**United Utilities Water Limited
Developer Services & Planning**
Warrington North WWTW
Barnard Street off Old Liverpool Road
Gatewarth Industrial Estate
Sankey Bridges
Warrington
WA5 1DS

Your ref: 3/2015/0972
Our ref: DC/15/3766
Date: 21-DEC-15

Location : Haydock Nursing Home, Pleckgate RD, Ramsgreave
Proposal : proposed 10bed two storey extension to existing care home

SITE AREA PLAN (PROPOSED)

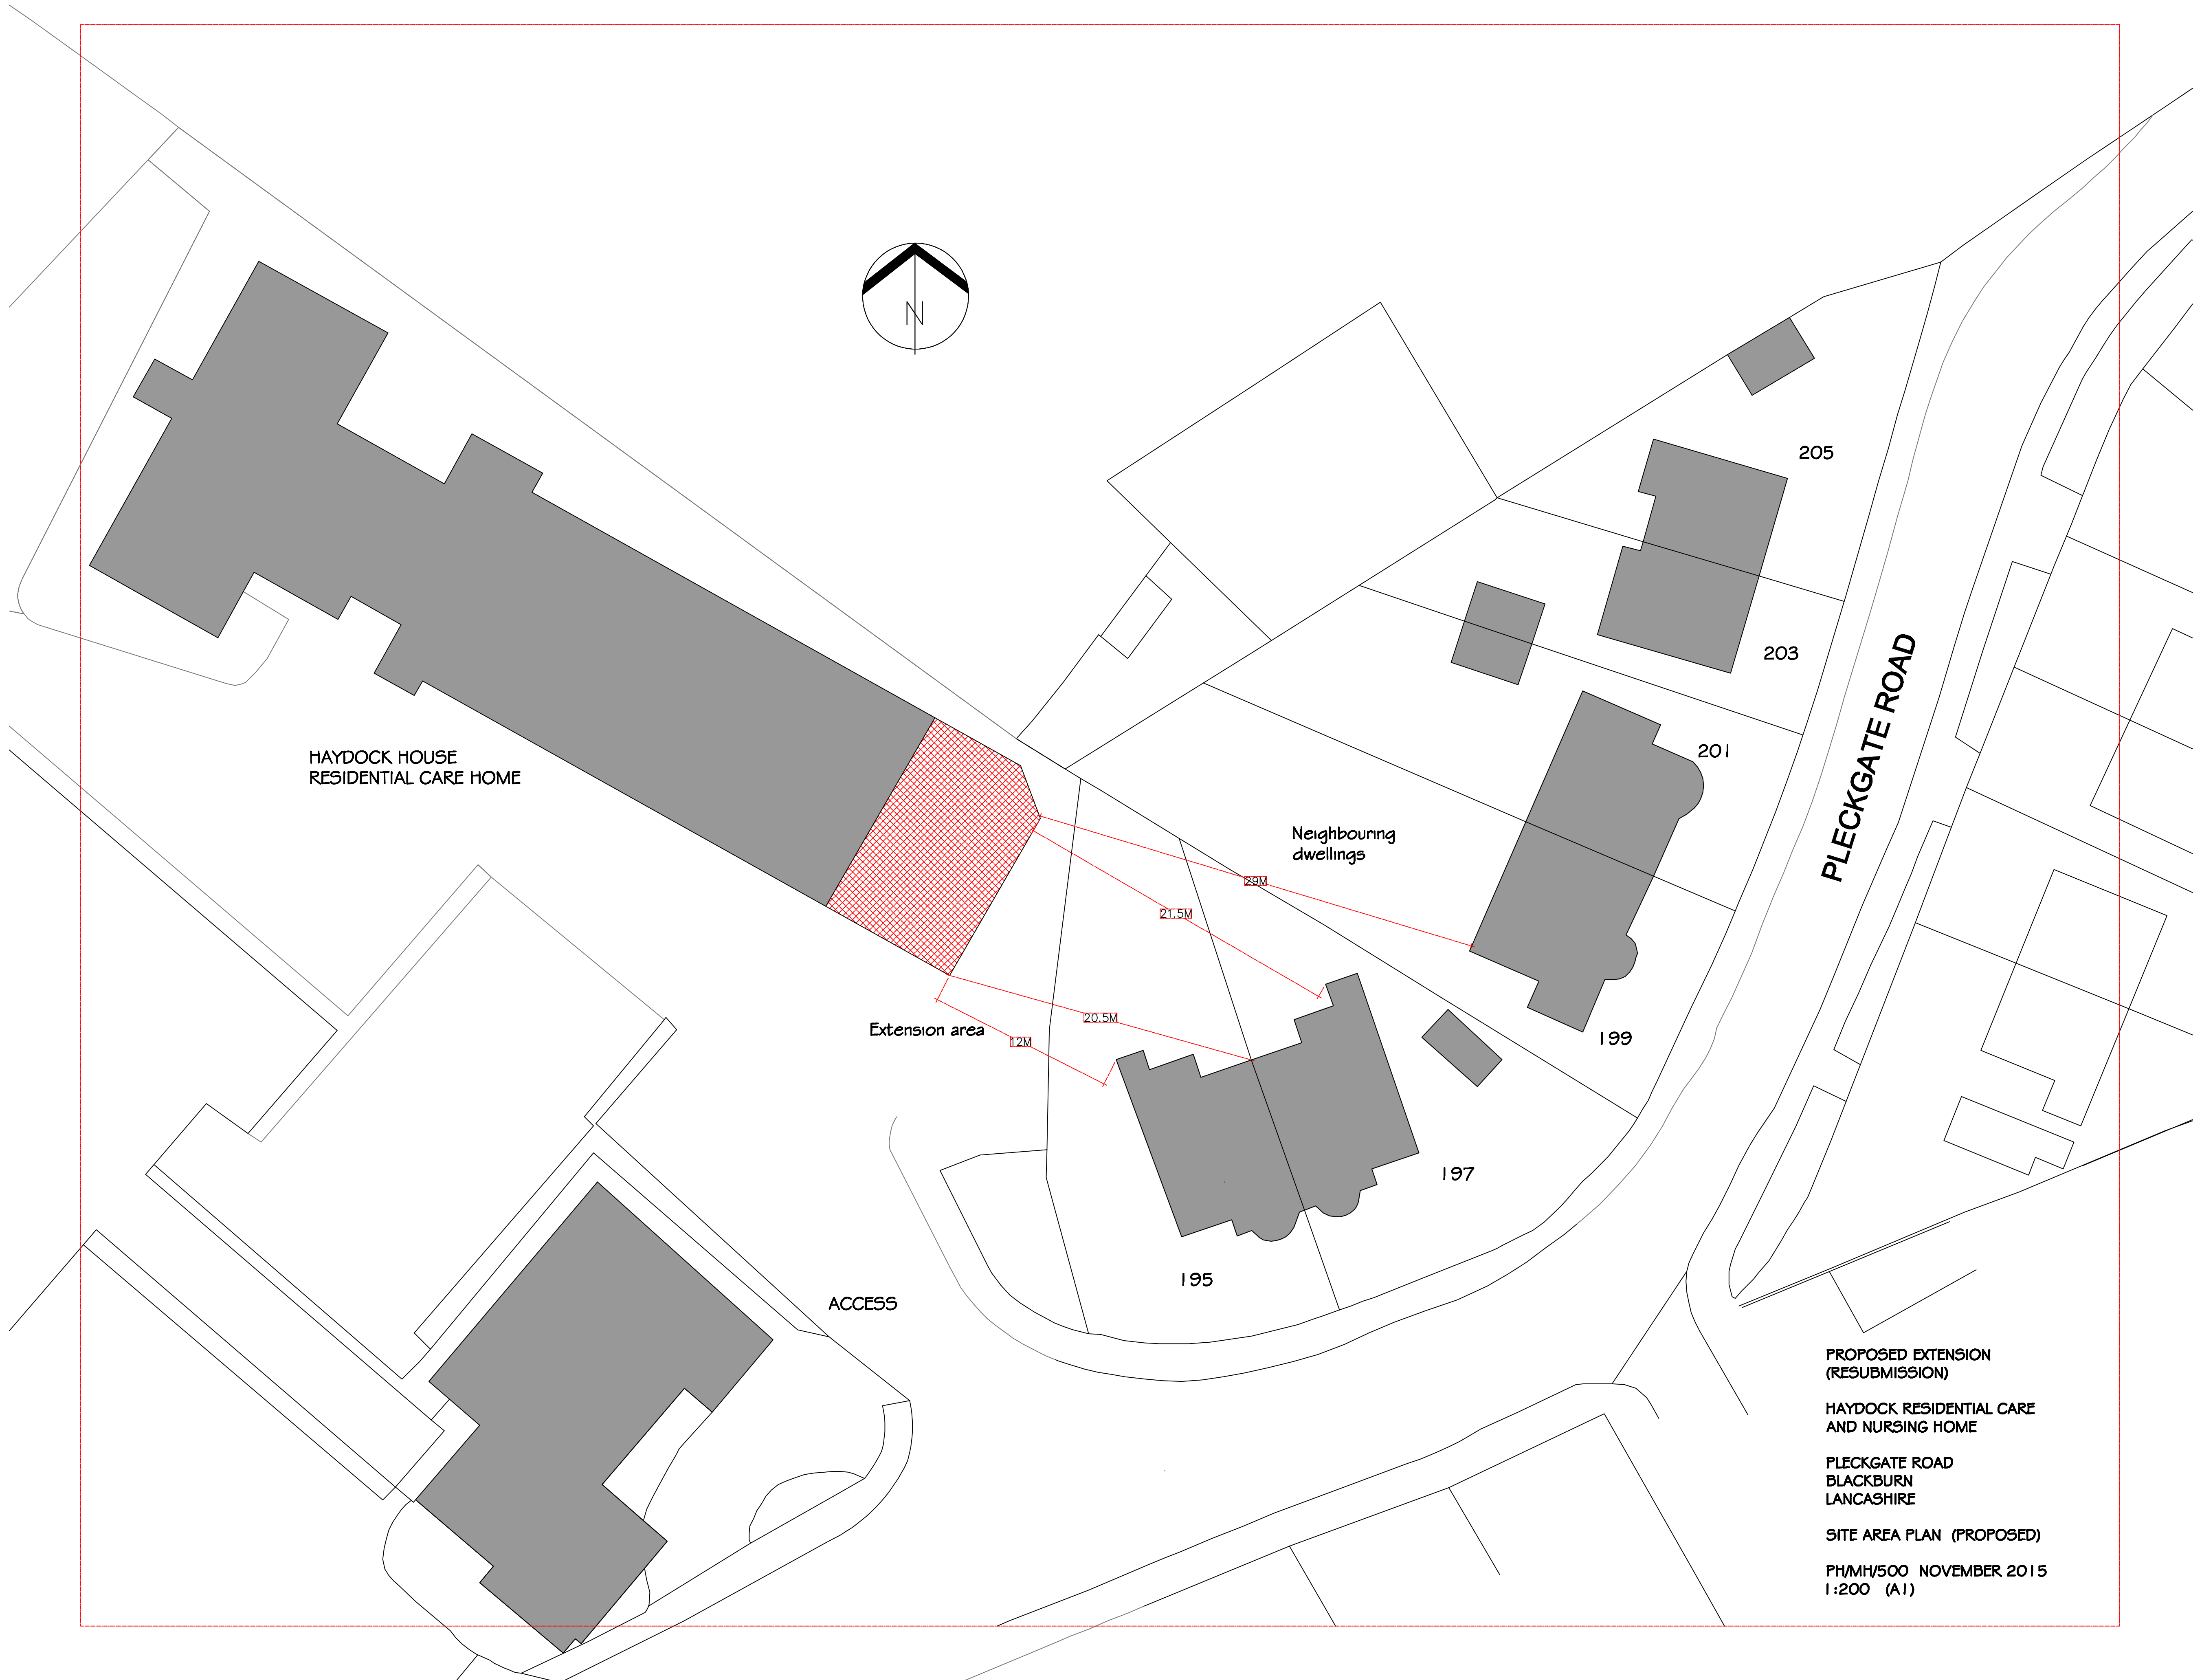
According to our records there is a 15ft easement (F3300 F3290 dated 14/05/1964) protecting a water main that runs through the proposed development site. Under no circumstances should anything be erected, planted or stored over the easement width, nor should anything occur that may affect the integrity of the pipe or United Utilities legal right to 24hr access.

A water main/trunk main crosses the site. As we need access for operating and maintaining it, we will not permit development in close proximity to the main.

You will need an access strip of no less than 10 metres, measuring at least 5 metres either side of the centre line of the pipe.

This should be taken into account in the final site layout, or a diversion will be necessary, which will be at the applicant's expense.
